Our ref: DOC22/1006051
Your Ref: SSD-35538829

Subject: Exhibition – Parramatta Metro - Over Station Development (SSD-35538829)

Attachment 1 – EHG comments - Parramatta Metro - Over Station Development (SSD-35538829)

**Figure 6-1 PMF Levels at the proposed site**

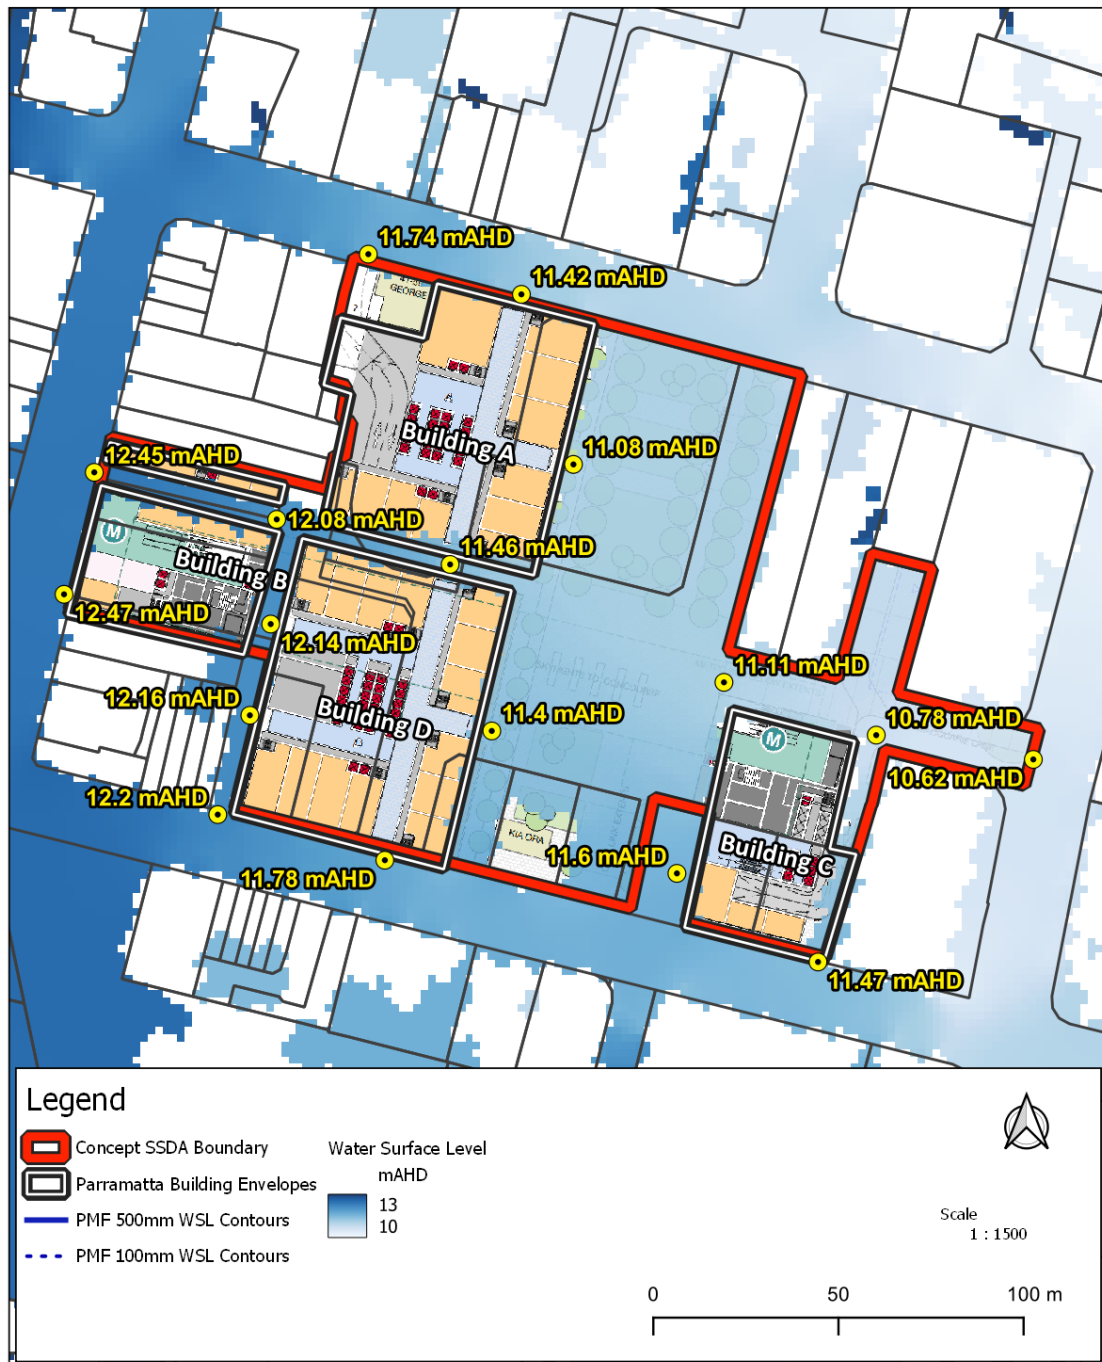
Flood barriers are proposed to protect the Building A basement from flooding up to the PMF. Potential barriers for entries that form part of the Sydney Metro West Stage 3 Critical State Significant Infrastructure (SSI-22765520) are not discussed here. Basements should be afforded passive protection to the PMF level. It is likely that the risk of failure of barriers is even higher for commercial or residential buildings than for metro stations.

For the concept stage, proper consideration of flood emergency management is required for ground floor retail/commercial areas that do not have internal access to refuge areas, nor protection to the PMF. While the report recommends shelter in place, no detail has been provided for these areas. Noting the lack of warning time, internal access to refuge areas would be required. EHG strongly recommends that the proponent demonstrate the development does not create an unacceptable risk to life. As a minimum, a set of principles should be provided and it should be checked that each of the tenancies or areas can comply with these principles.
